**From:** Mike Flory  
**Sent:** Thursday, April 8, 2021 5:42 PM  
**To:** Jeremiah Cromie  
**Subject:** RE: LL-21-00001 Bailey - Notice of Application

### MEMORANDUM

SUBJECT: LL-21-00001 Bailey

BAILEY SHORT PLAT PART OF SECTION 15, T. 16 N., R. 20 E., W.M. KITTITAS COUNTY, WASHINGTON

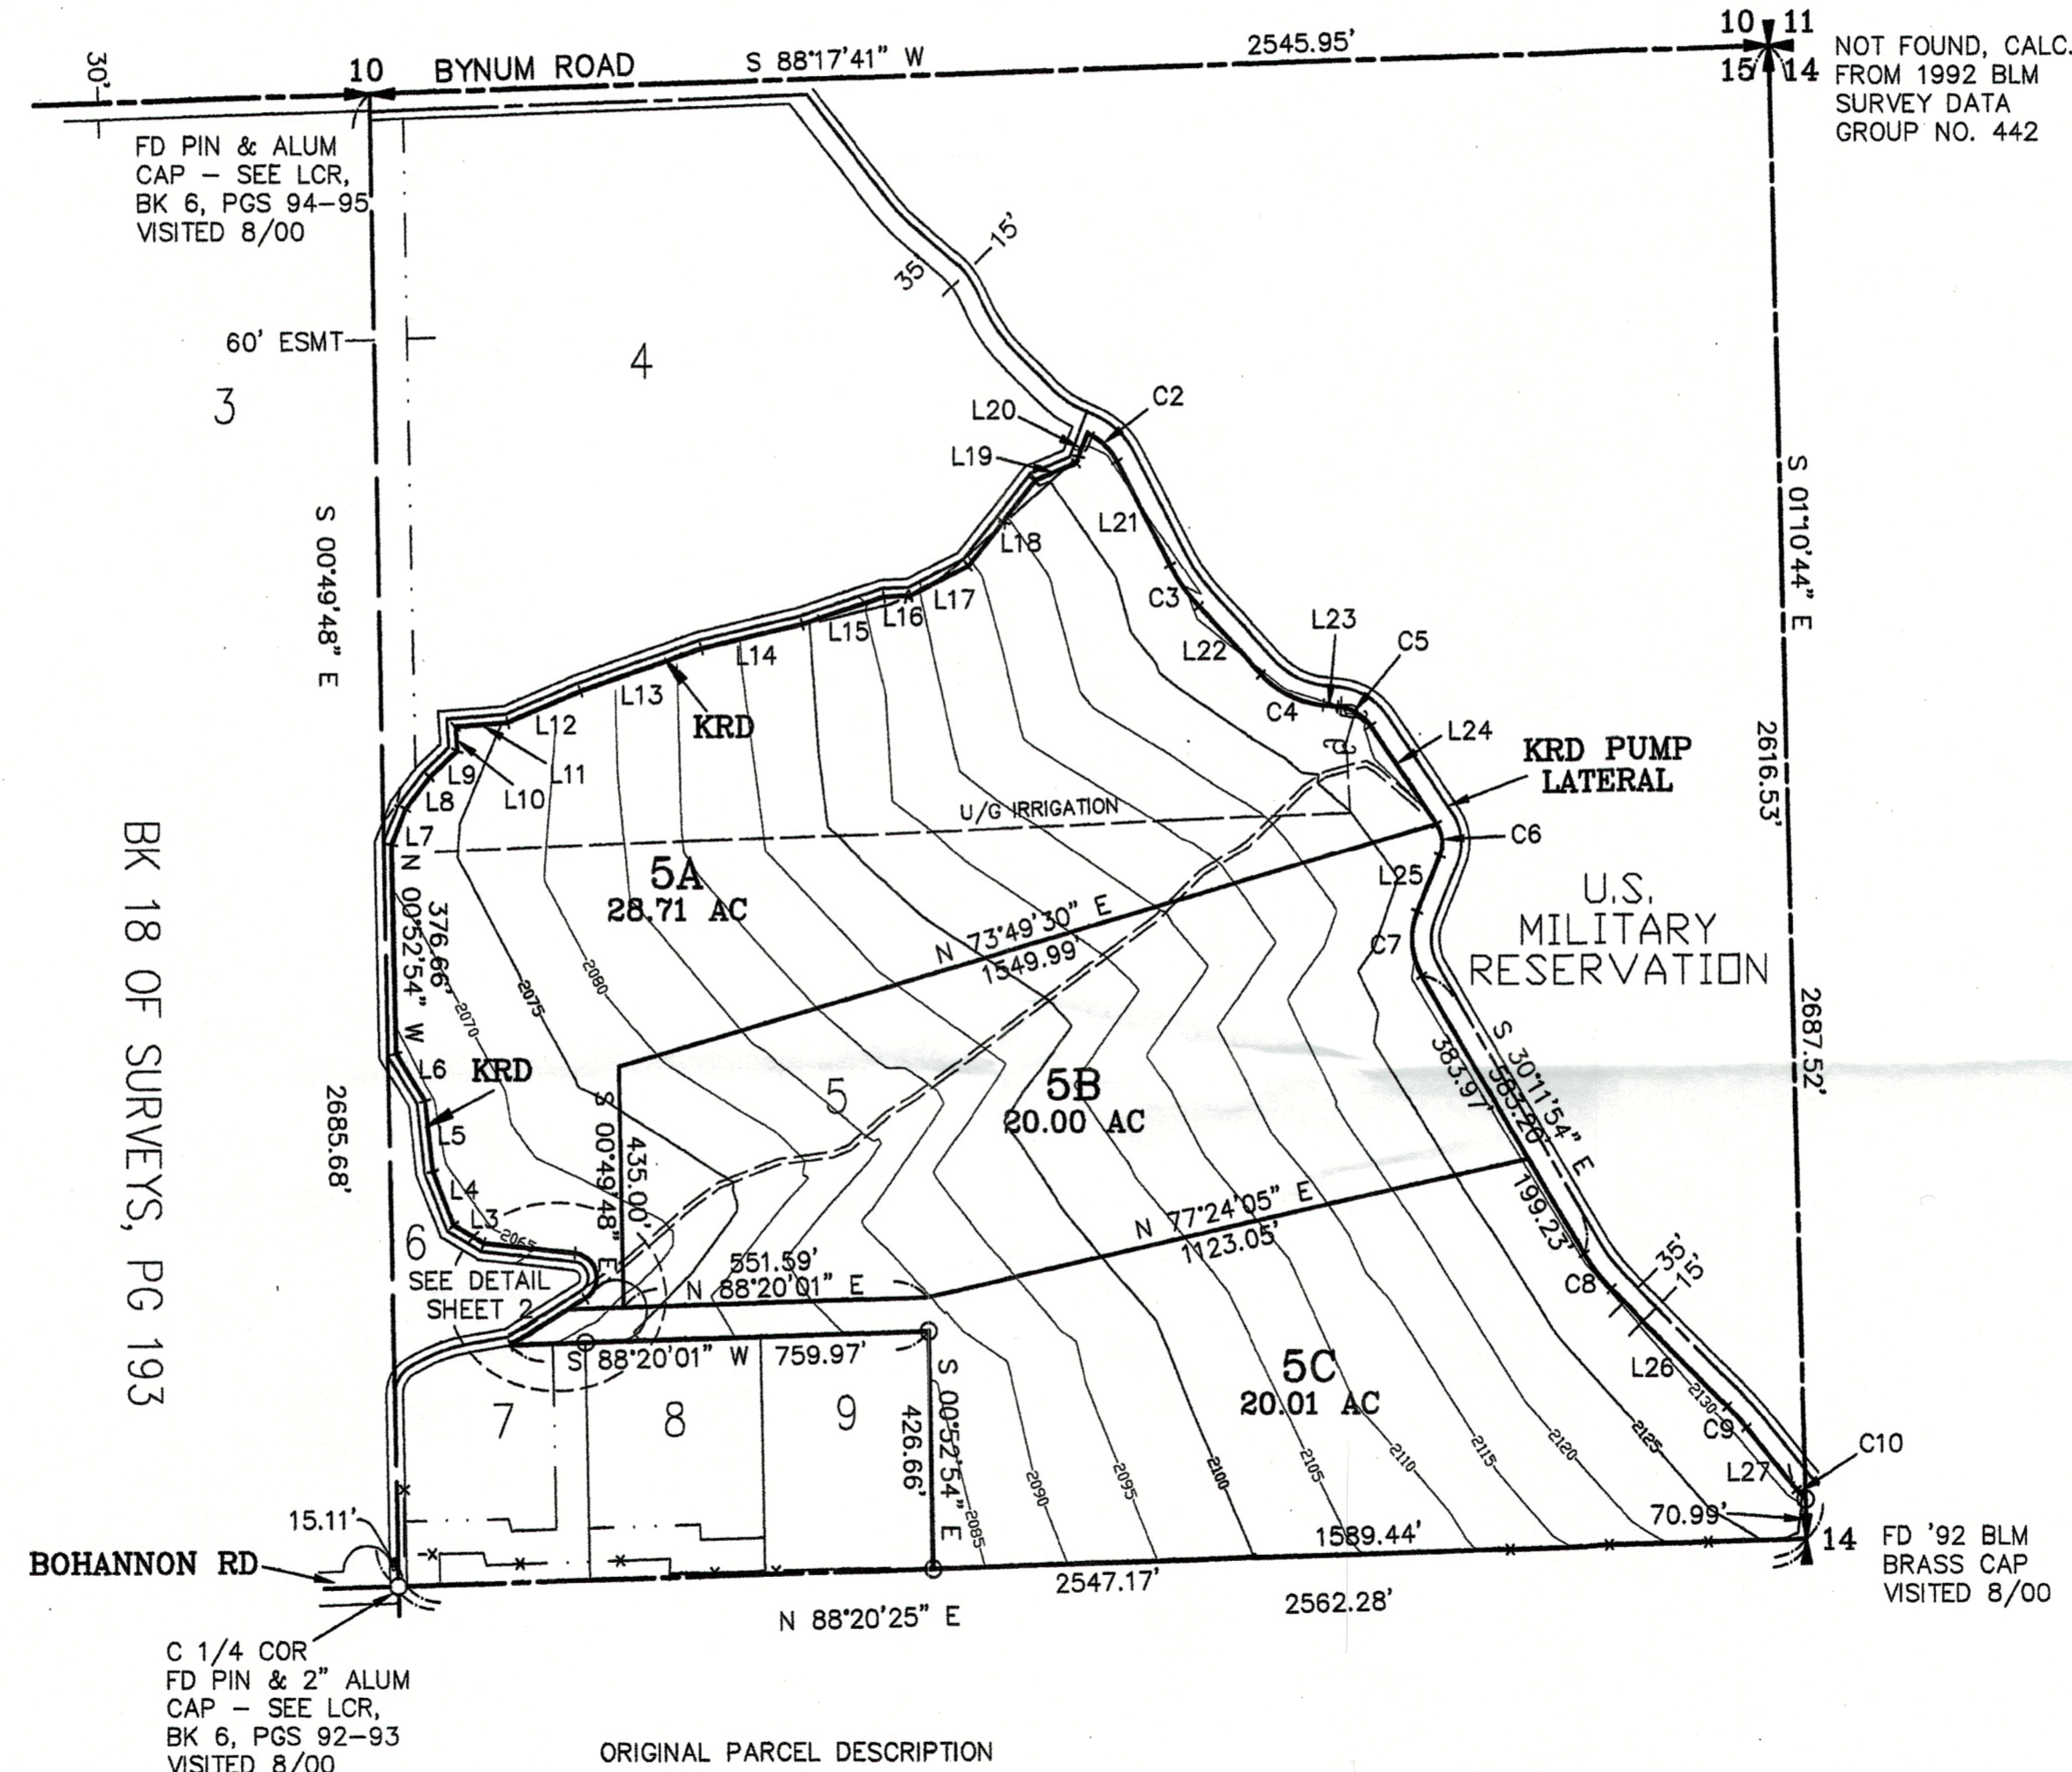
Thanks for the opportunity to comment. WDFW's only comment on this proposal is that the watercourse shown as an irrigation ditch does have a natural, although small, watershed above the KRJ system. We would consider this a modified natural watercourse that is a tributary to Badger Creek. Under the County's current CAO, it is likely a Type 4 or 5 stream although we have not completed a site review on this parcel.

1. For all easements shown on the face of the map, please include the width and purpose of the easement (access/utility), and the recording number or map reference. For Easements that will be created as a result of the map being filed, please include language such as "herein dedicated".
2. Please show corners set for the new division lines between parcels.
3. The basis of bearing has not been addressed.
4. Curve 'C10' is unclear if it is a curve to the left or the right.

6. There are multiple instances of text being obscured by crossing linework. This is primarily due to the contours. If the contours are removed prior to the recording of the final plat, this will not pose a problem.
